REQUEST

Current Zoning: R-3 (single family residential)
Proposed Zoning: UR-2(CD) (urban residential, conditional)

Approximately 11.65 acres located on the east side of Mallard Creek Road, north of Governor Hunt Road, and west of David Taylor Drive.

The petition proposes a residential community of up to 283 multifamily dwelling units together with accessory uses permitted in the UR-2 zoning district.

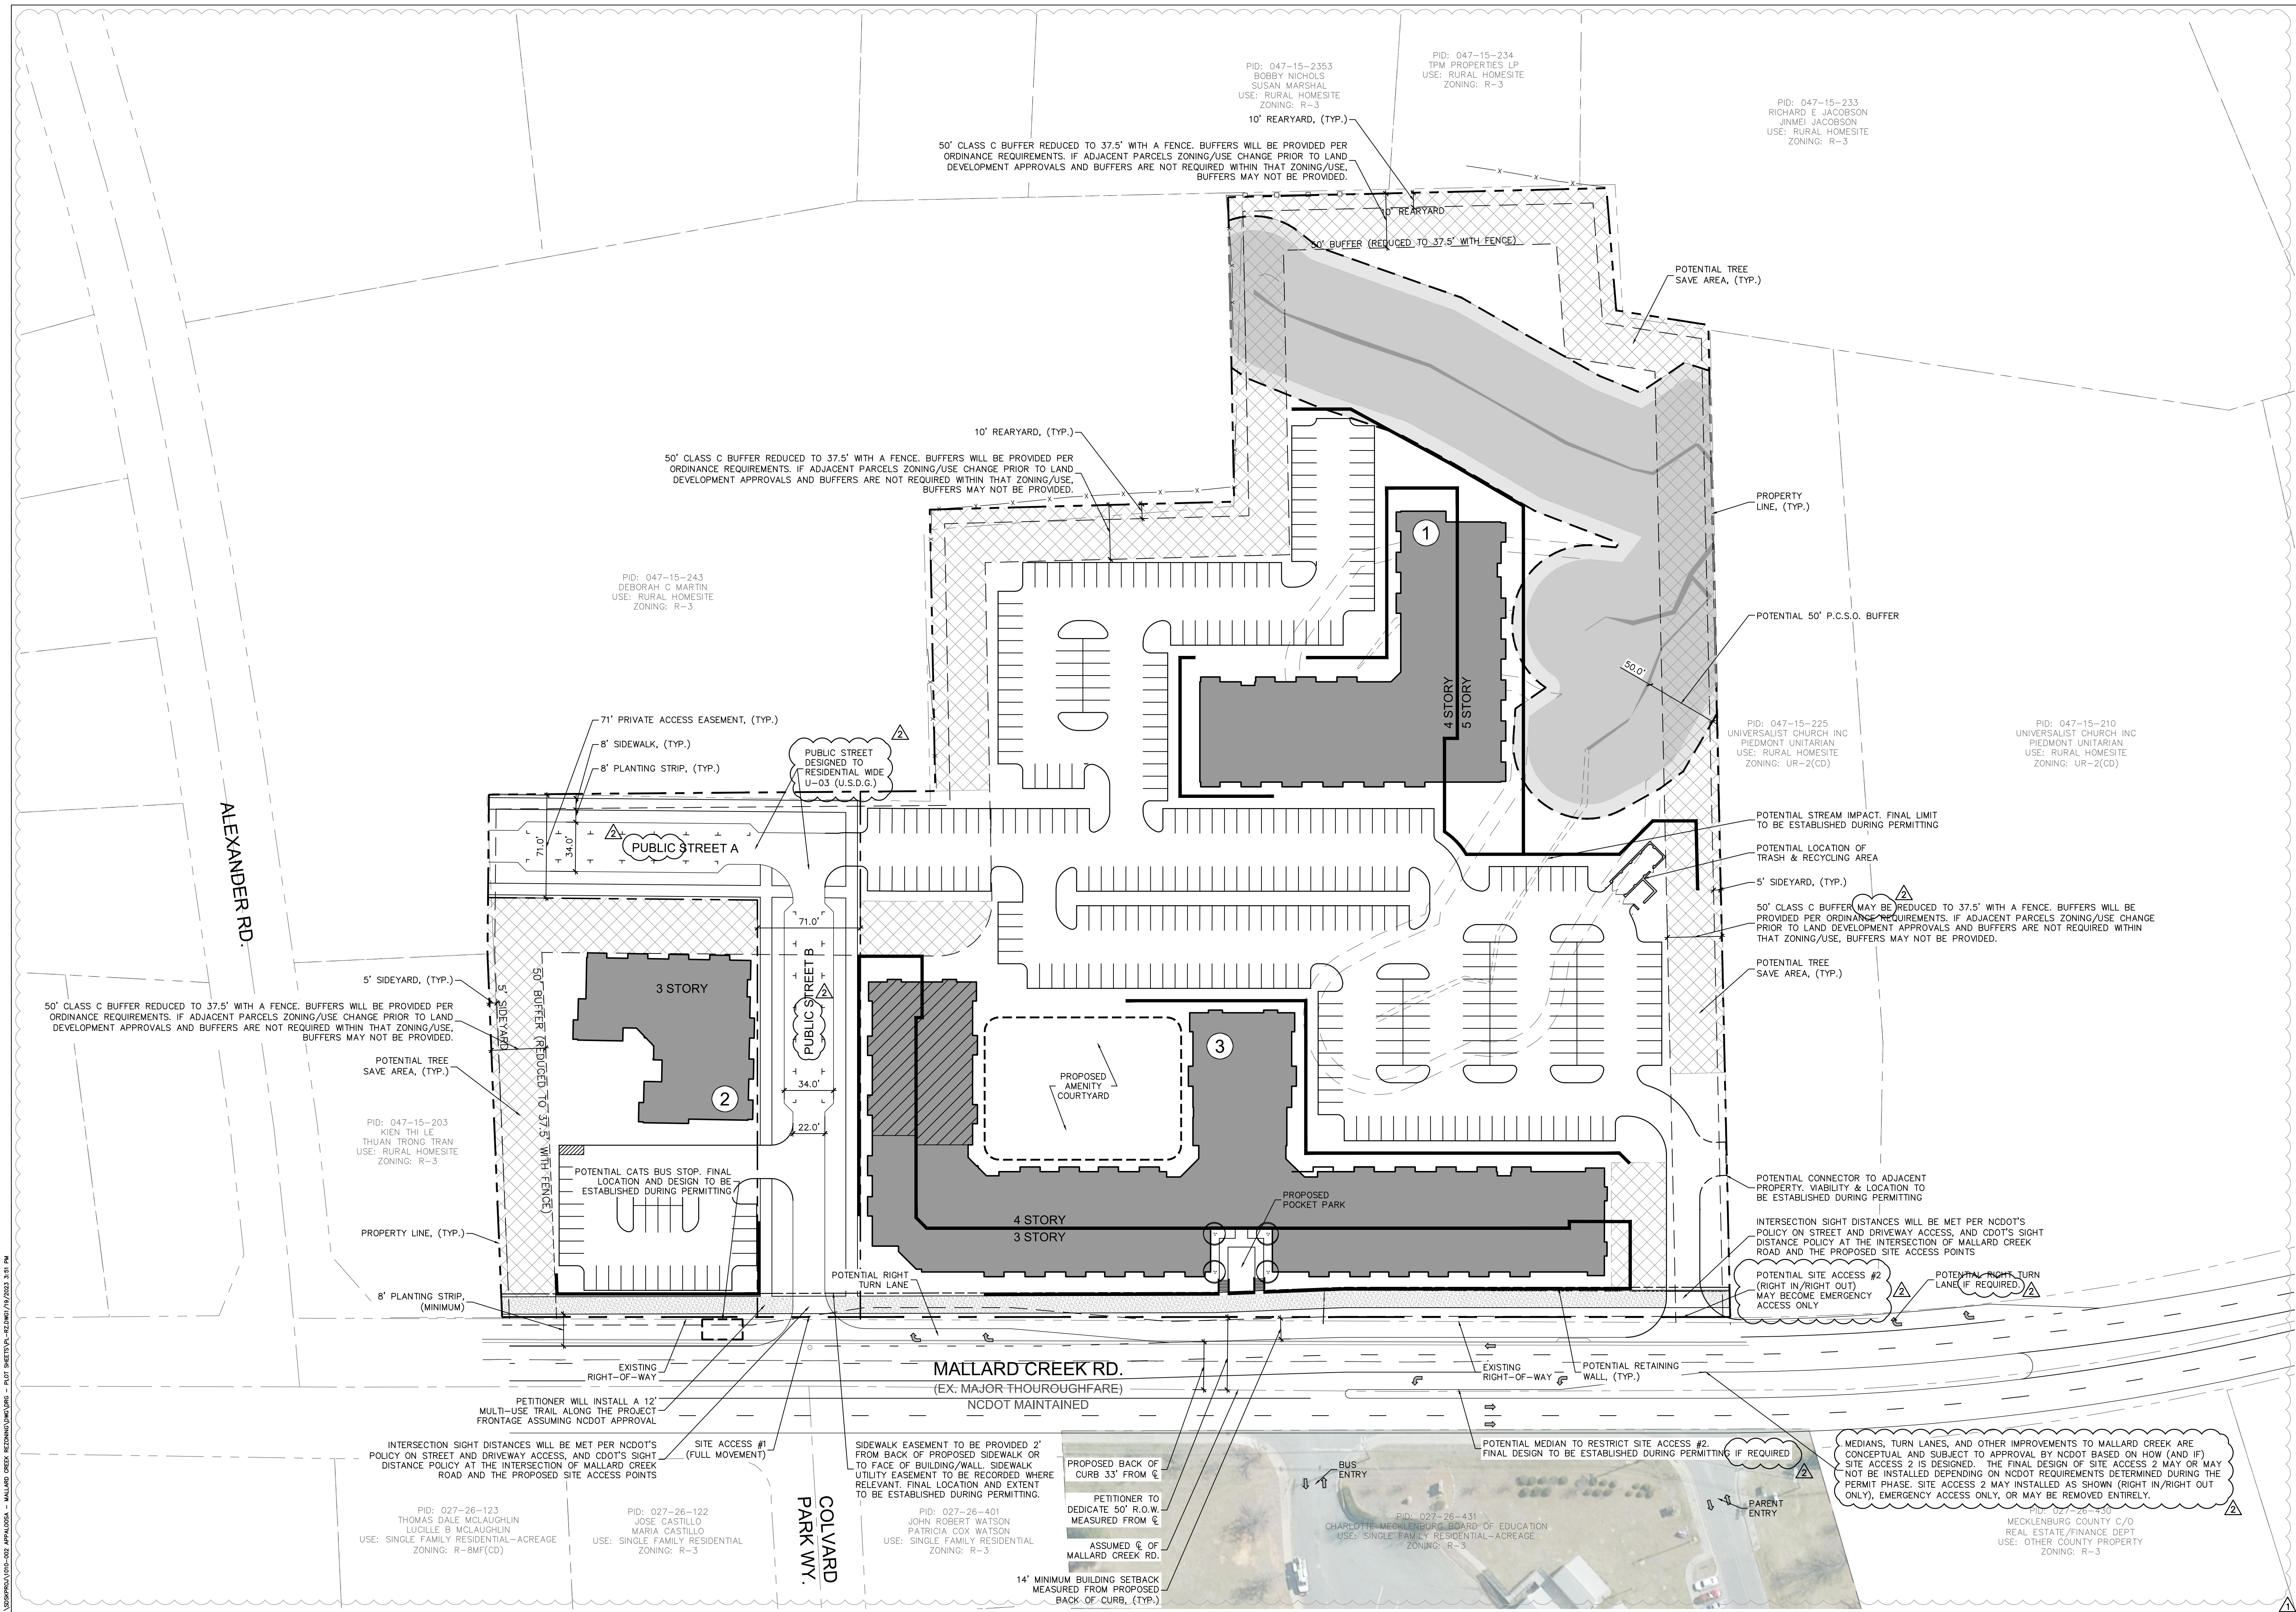
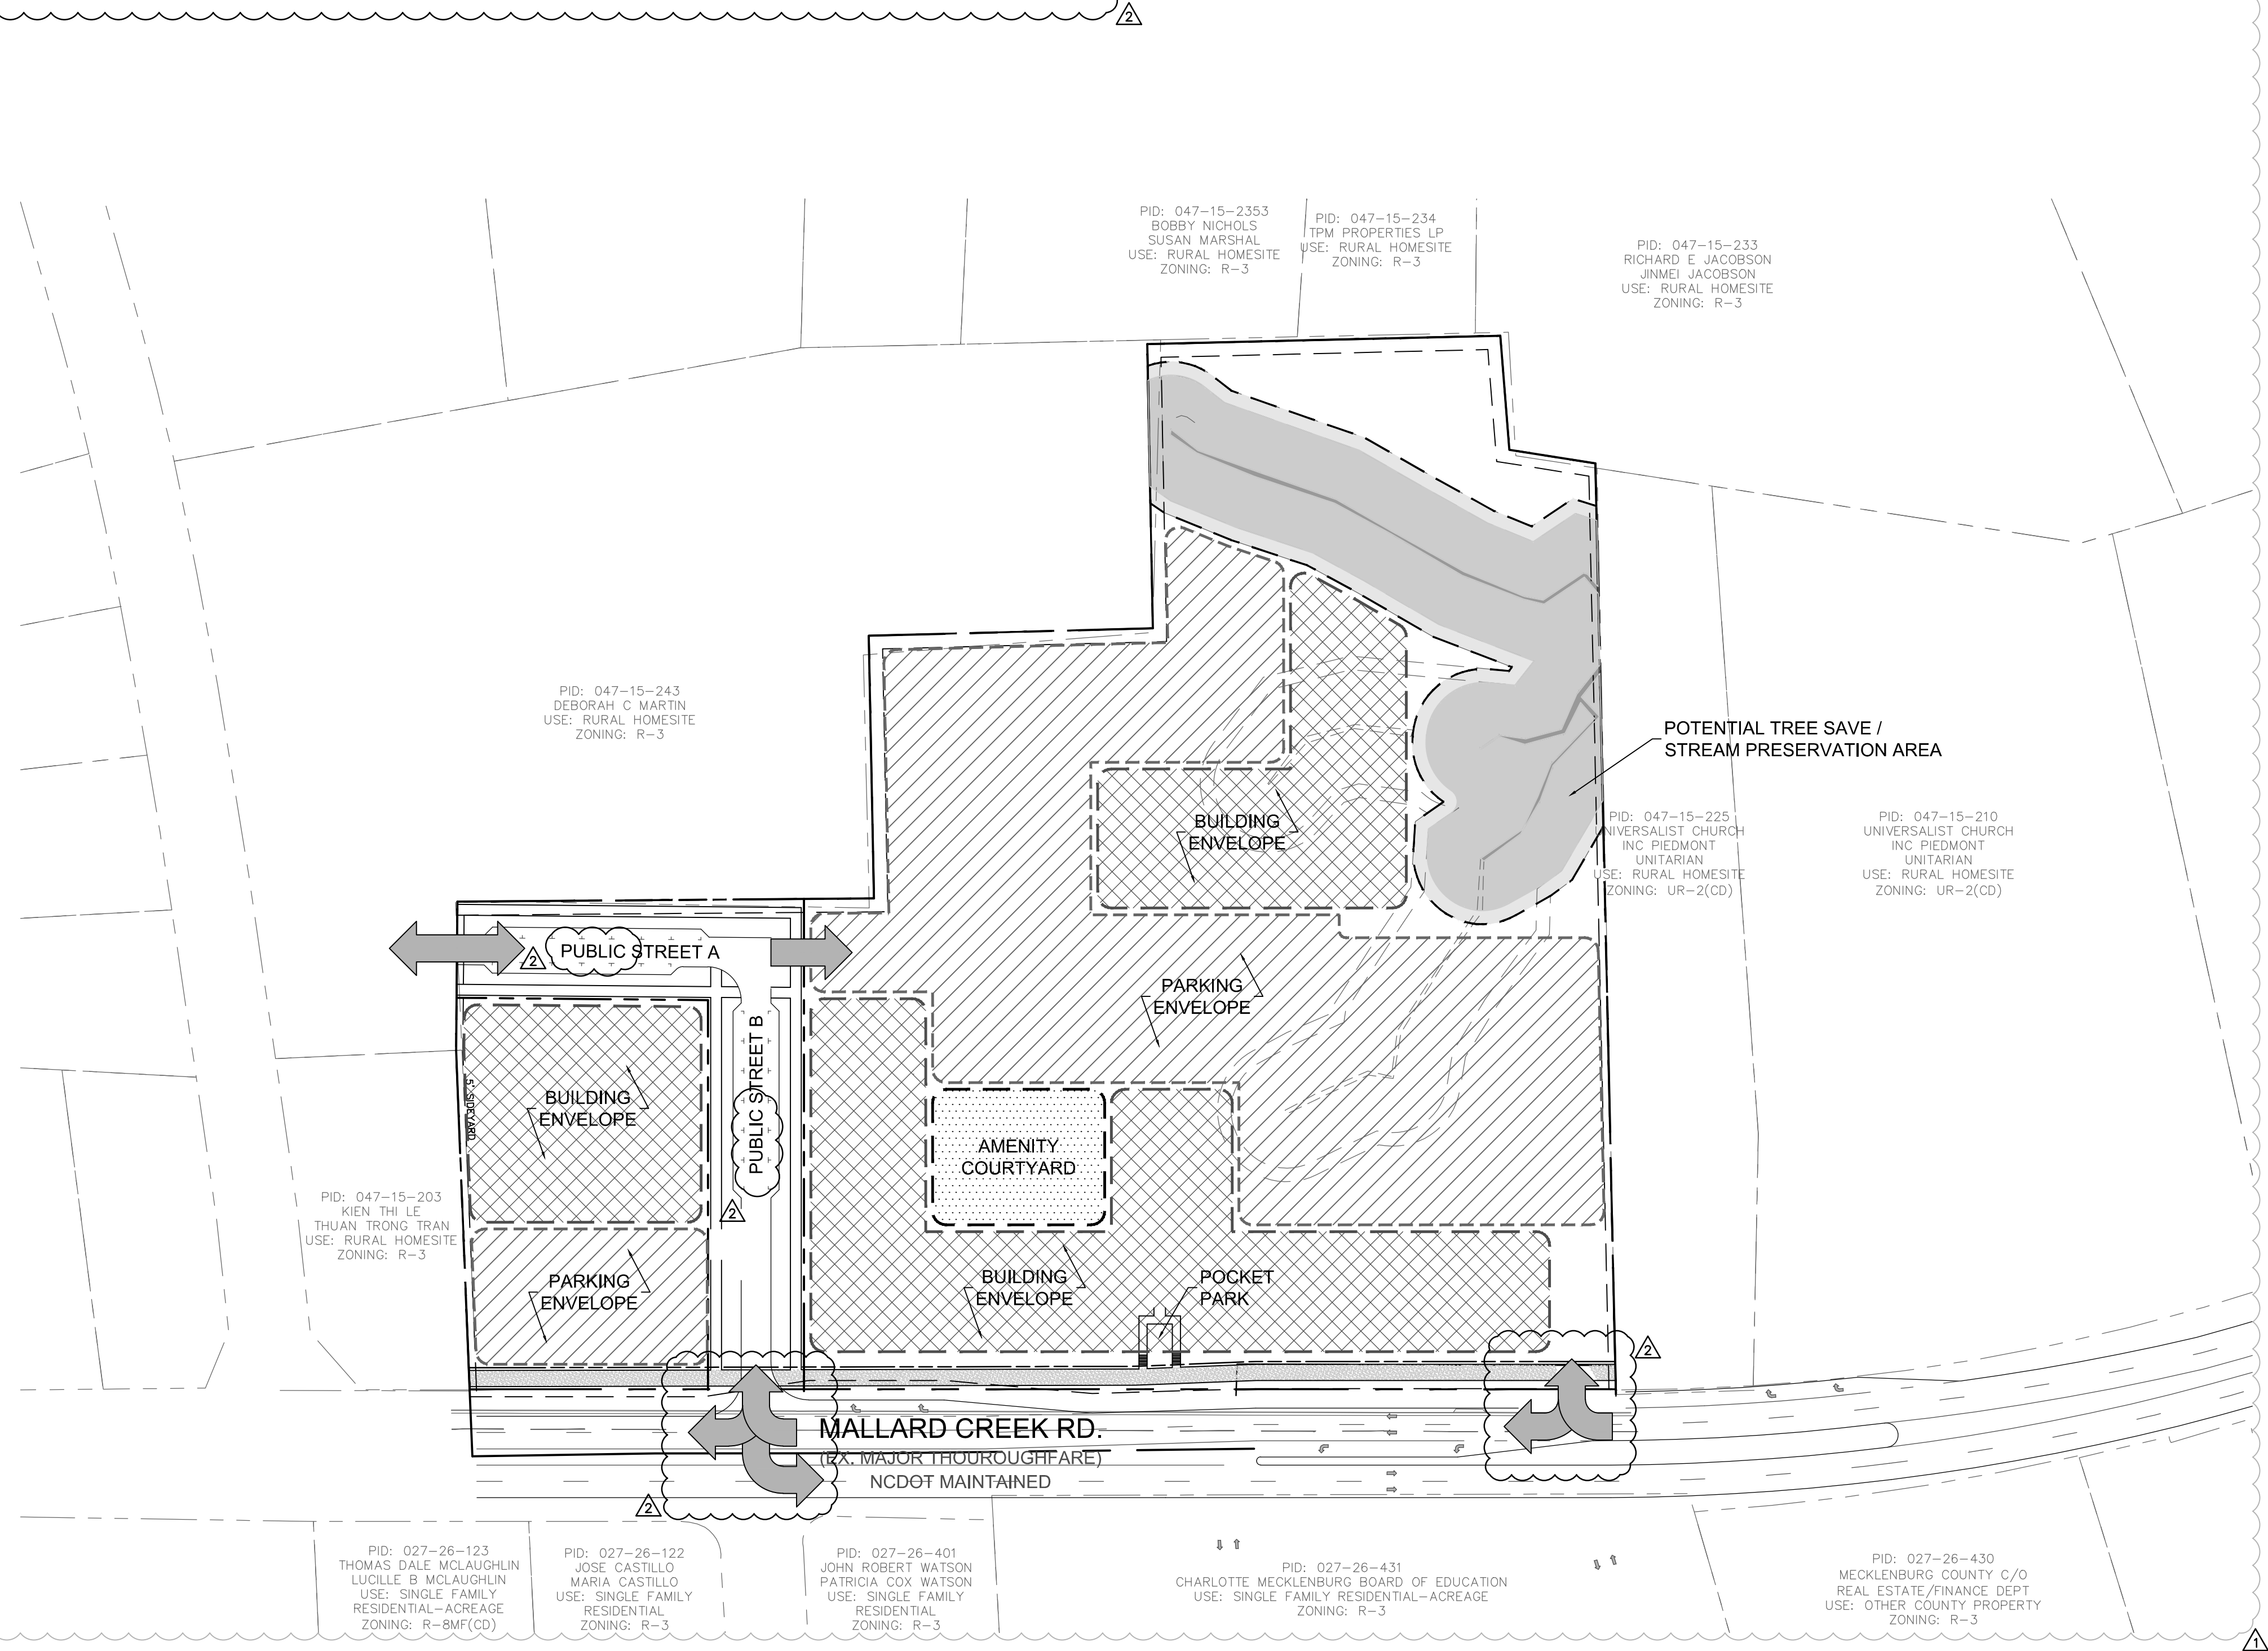
1. Private Street A and Private Street B will both need to be public streets per coordination with subdivision. Remove all references to private access easements for Private Streets A and B.
2. Modify median to ensure full movement for development adjacent can be retained from parcels 04715225 and 04715210. What is being proposed will create a change of access for the development adjacent to property.
3. Either remove conditional note L or add as approved by NCDOT/CDOT at the end.
4. Remove word "potential" on callout for right turn lanes at site accesses. This is an NCDOT requirement. Add conditional note regarding right turn lanes at each site access. Label and dimension right turn lanes.
5. Remove "assuming NCDOT approval" on callout for 12-foot multi-use trail.
